From: Louise Crane
Sent: 22 June 2017 13:53
To: Planning.Responses
Subject: FW: Planning Consultation on: BR/130/17/PL

APPLICATION **BR/130/17/PL**

Site Address: The Royal Hotel The Esplanade Bognor Regis PO21 1SZ

Description of Works: Change of Use of redundant hotel & function room/licensed bar (C1 Hotel) to 18No. flats (C3 Dwellinghouses). This application affects the character and appearance of The Steyne Conservation Area. Resubmission of BR/155/15/PL (10 No. Flats)

Proposed First and Second Floors

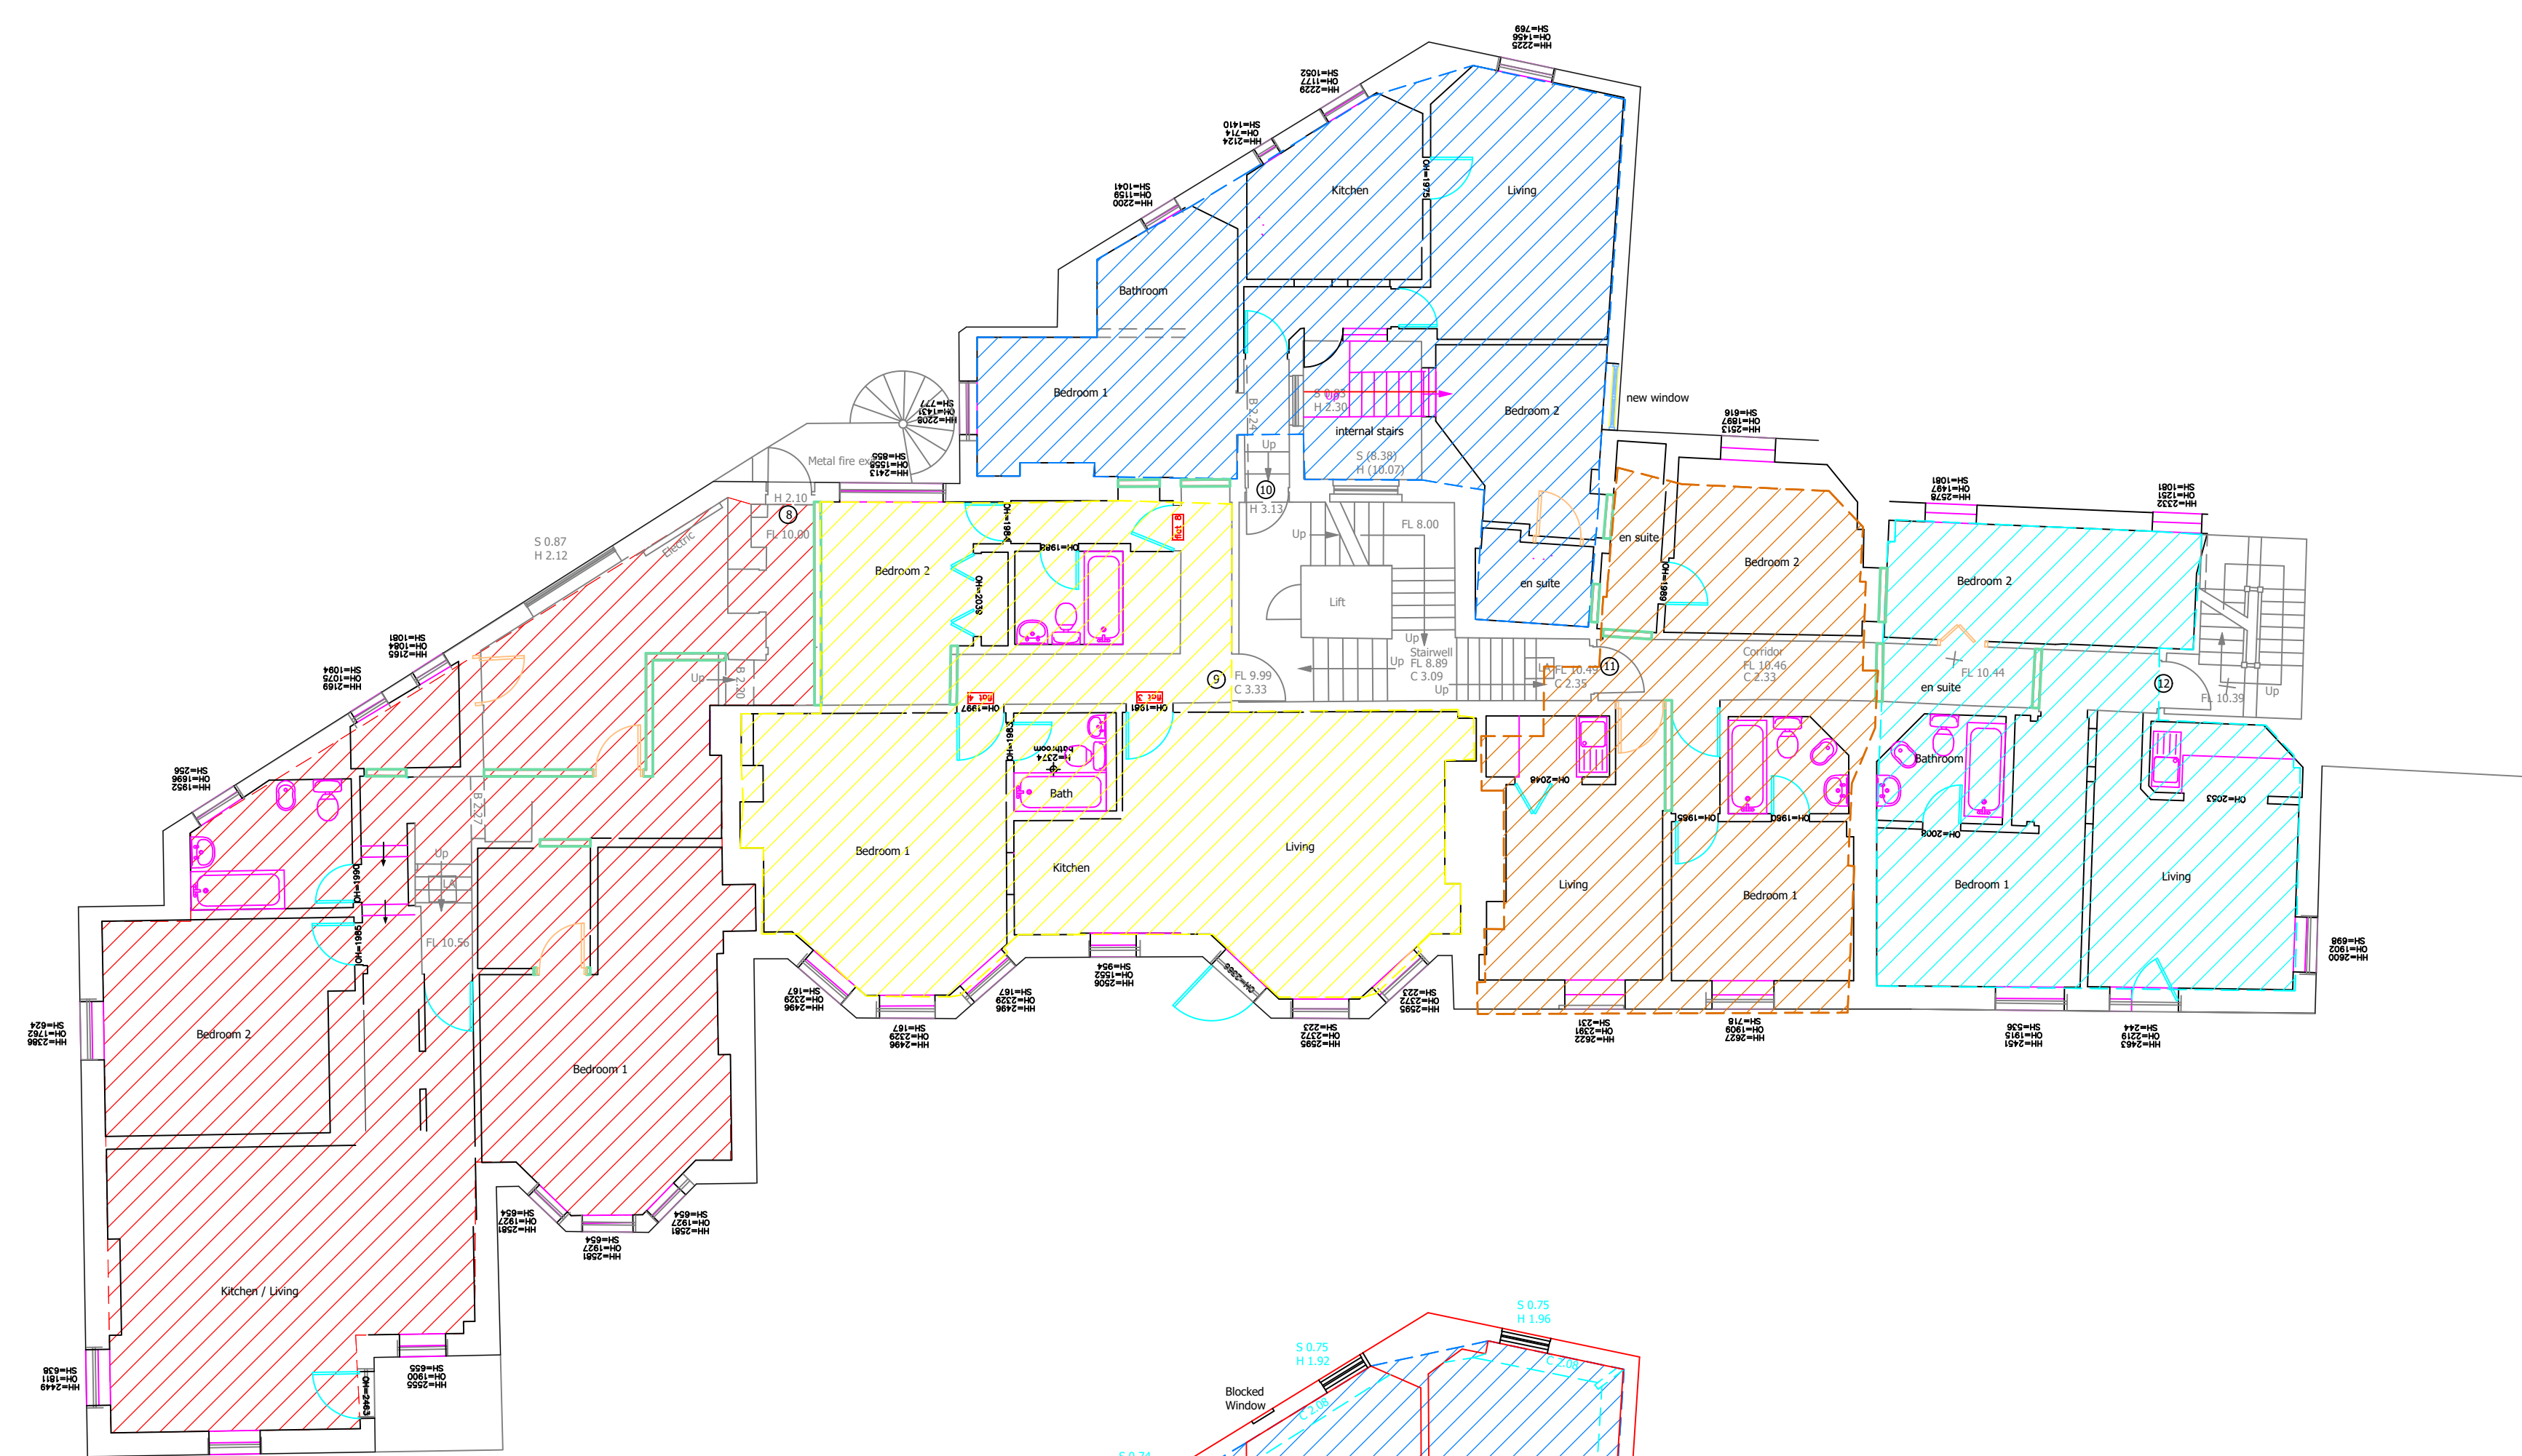
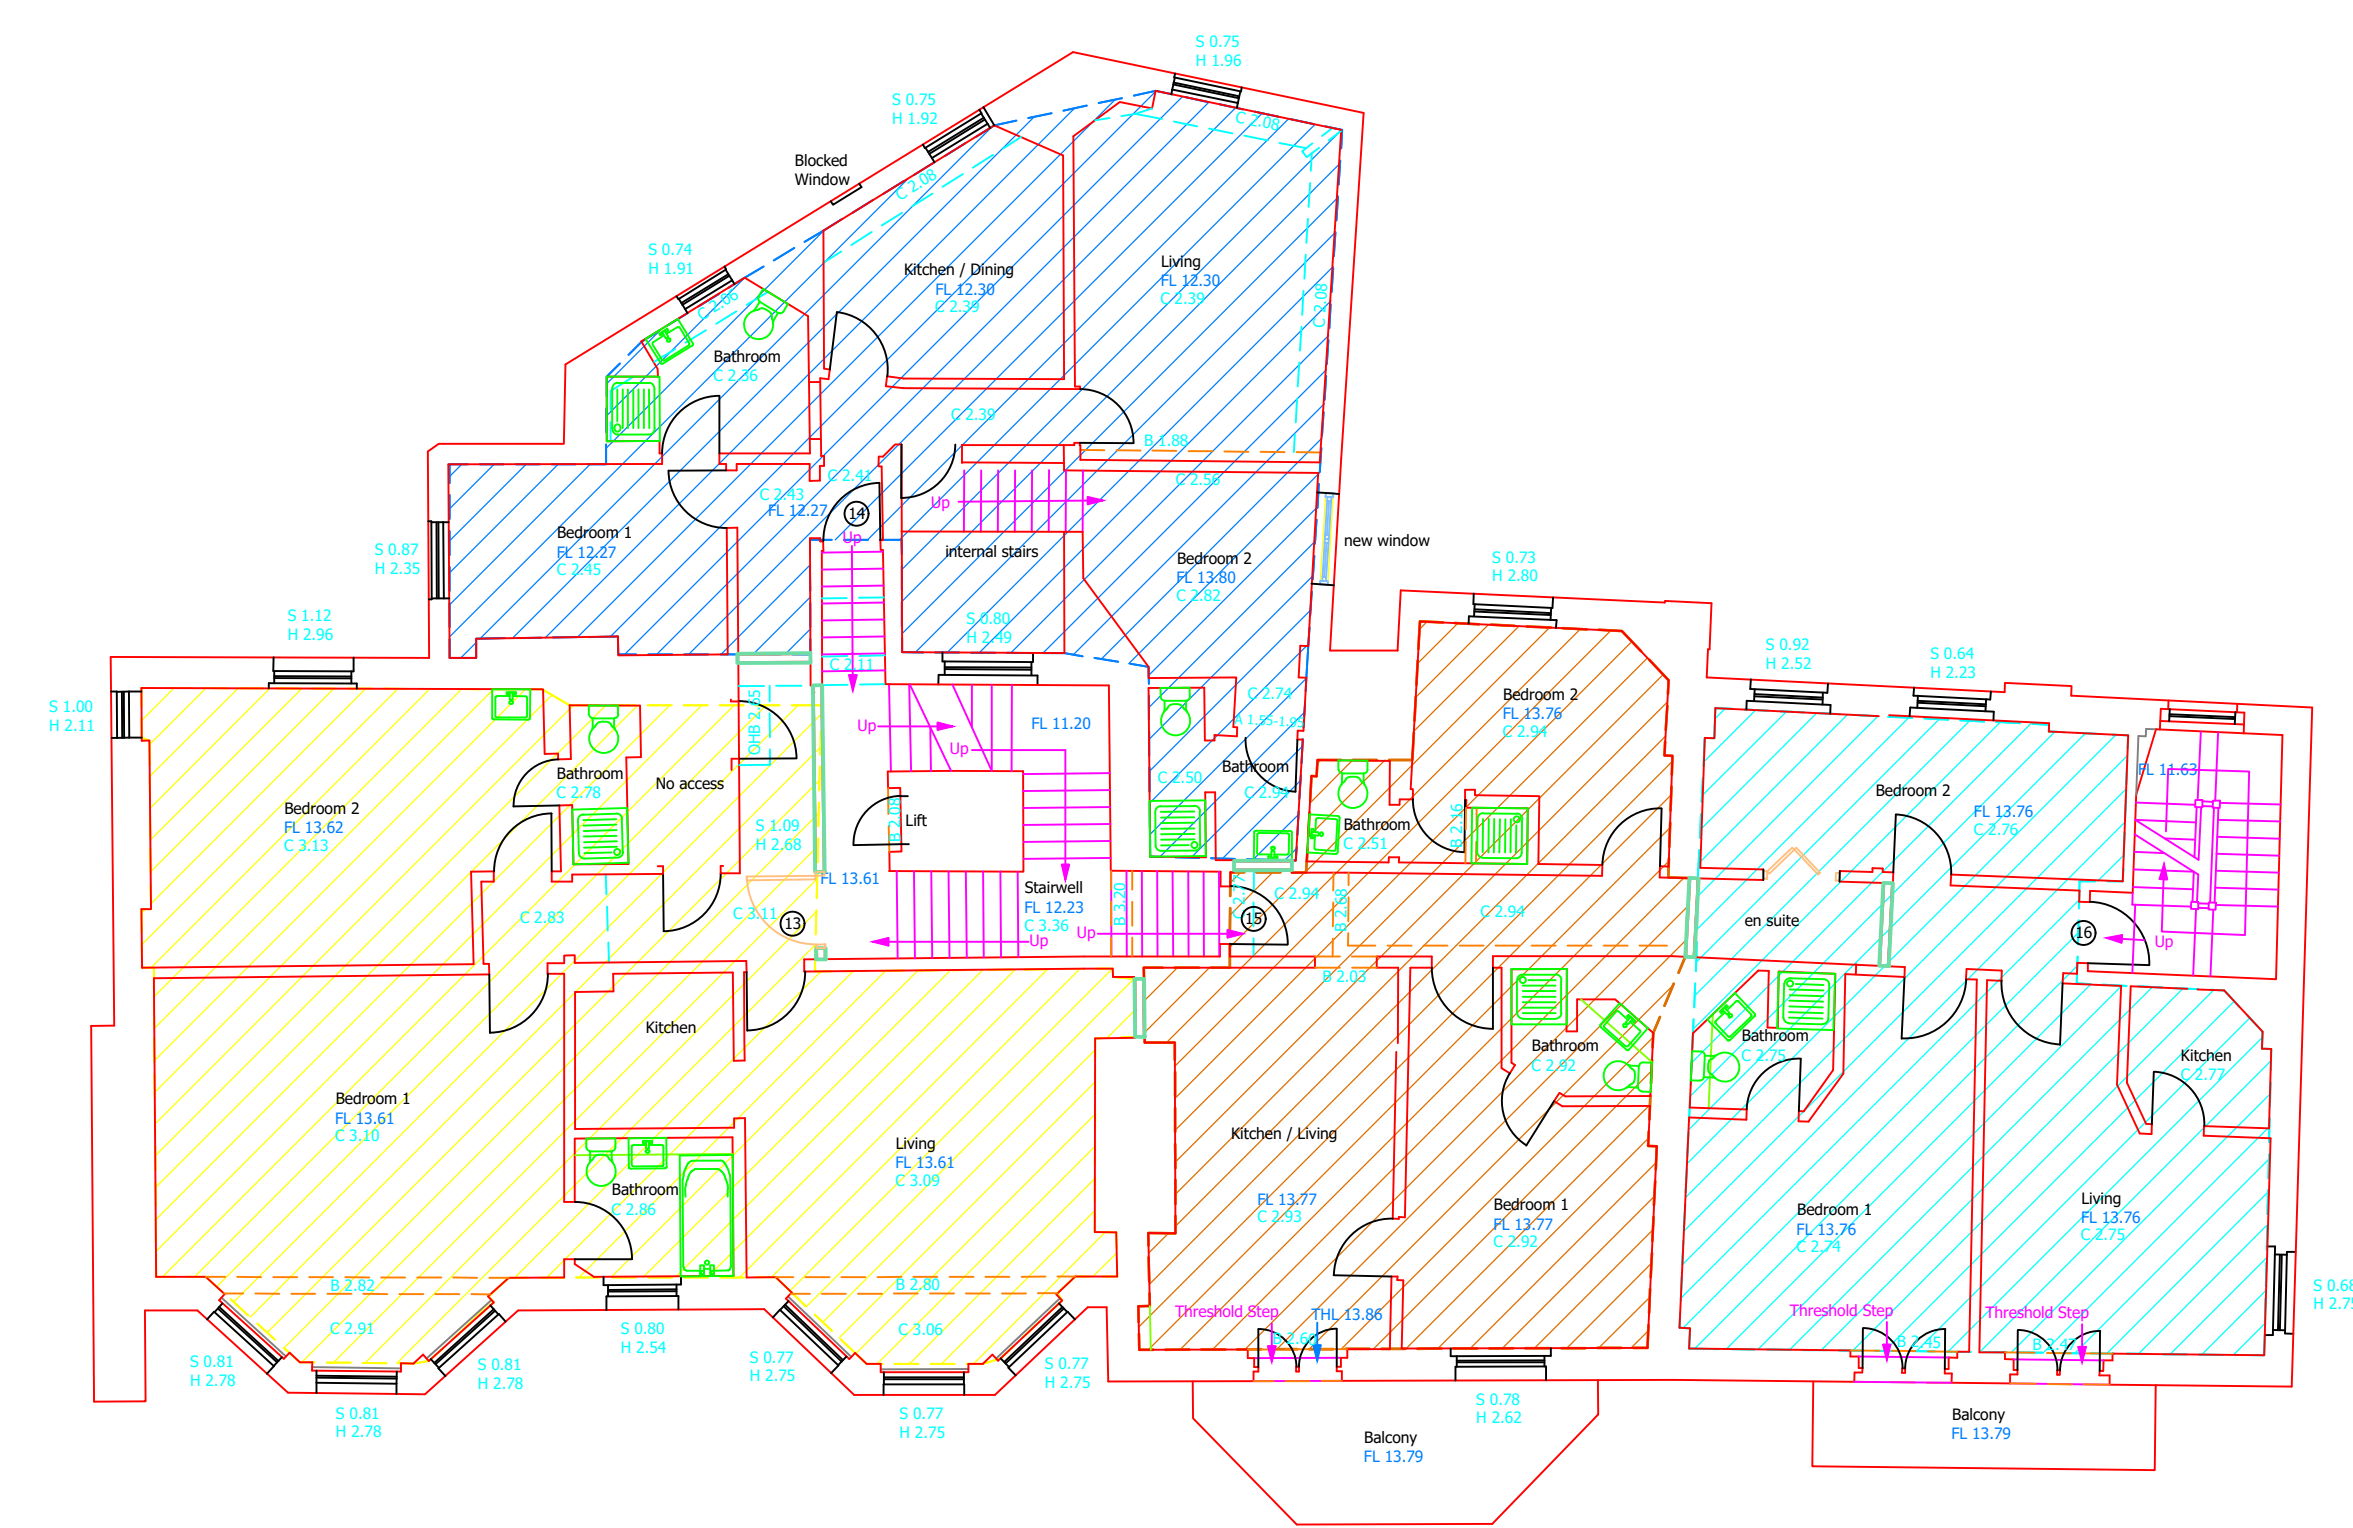
- A room where the only escape route is through another room is termed an "inner room" and poses a risk to its occupiers if a fire starts unnoticed in the outer room. There are a number of rooms which appear to be inner rooms, this can be overcome on ground and first floor by the provision of escape windows, however, alternative layouts would need to be considered on 2nd floor or lower ground if this is not possible.
